CITY OF ALBUQUERQUE

RE: **Sage Park Subdivision
Sage and Coors SW
Grading and Drainage Plan
Engineer's Stamp Date: 3/20/20
Hydrology File: L10D030**

Based on the submittal received on 4/17/20, this Grading and Drainage Plan cannot be approved until the following corrections are made:

Figure 1 - Sage Pond Basin

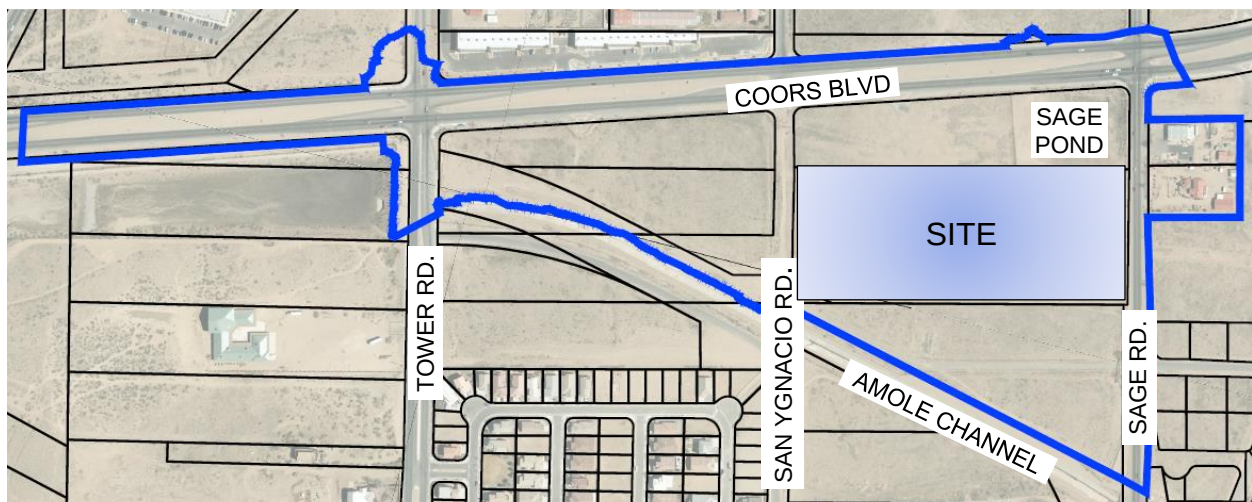
1. Please provide County permission for the work on their property and the right to discharge to the Sage Pond. This pond is on County property. Please also provide any documentation that states what the pond's function is or what areas it was built to serve and the ownership and maintenance responsibility.

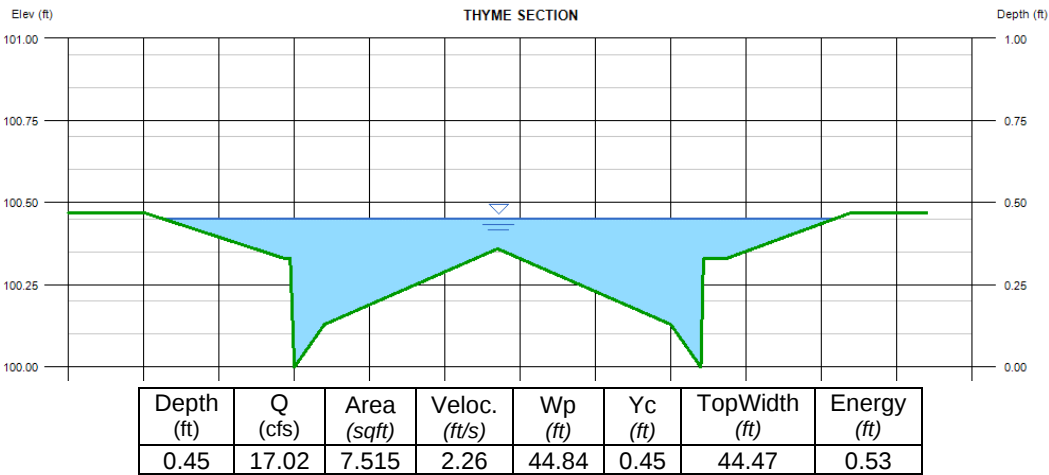
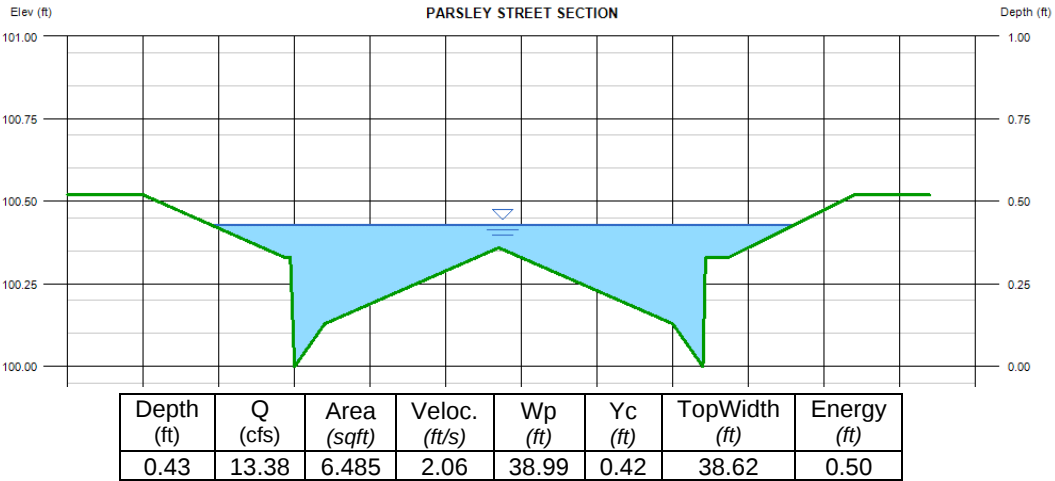
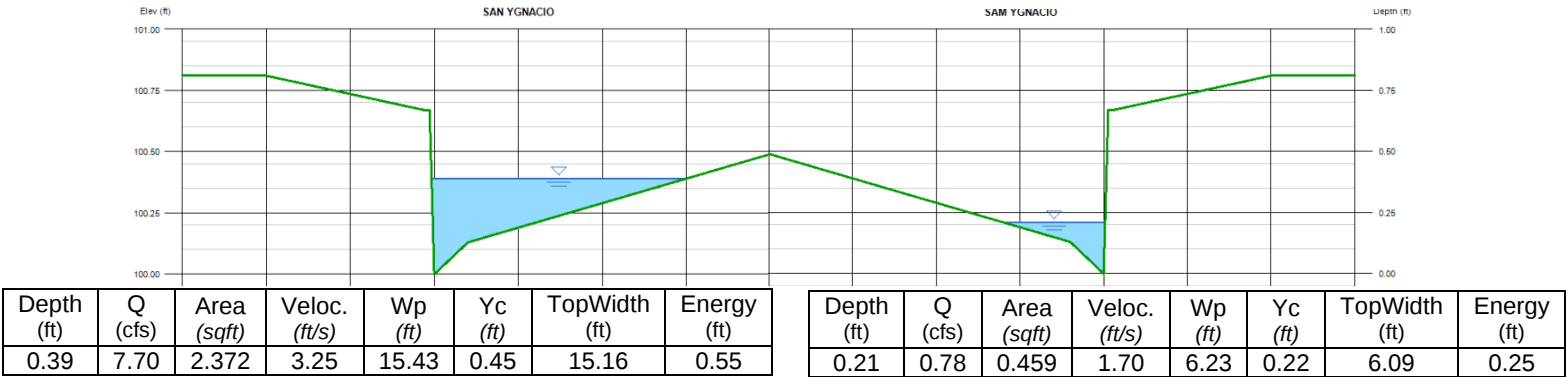
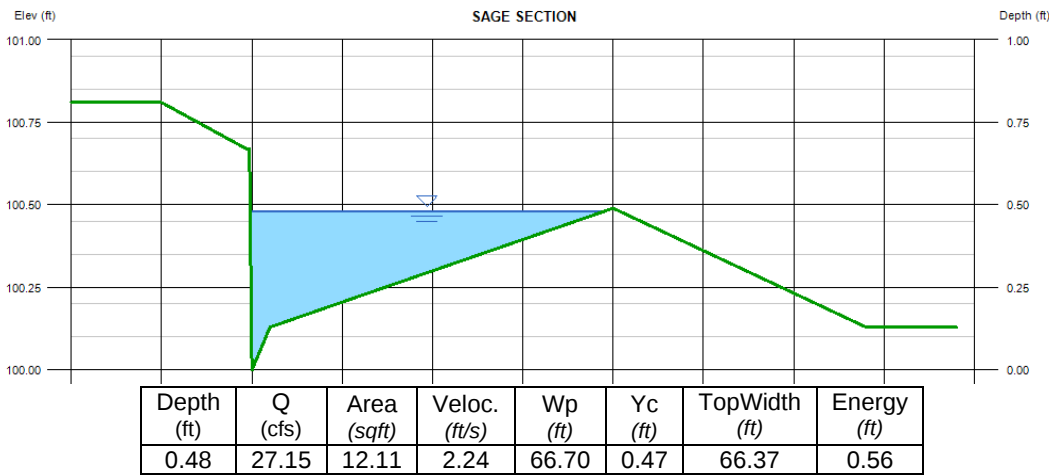
3. In the initial report the acreage for Basin 5 is incorrect. Please correct and recheck your calculations to ensure all values are correct.
4. Provide waterblocks, 0.87' minimum (or energy and flow depth calculations) for the following intersections: San Ignacio & Thyme, Parsley & Sage.
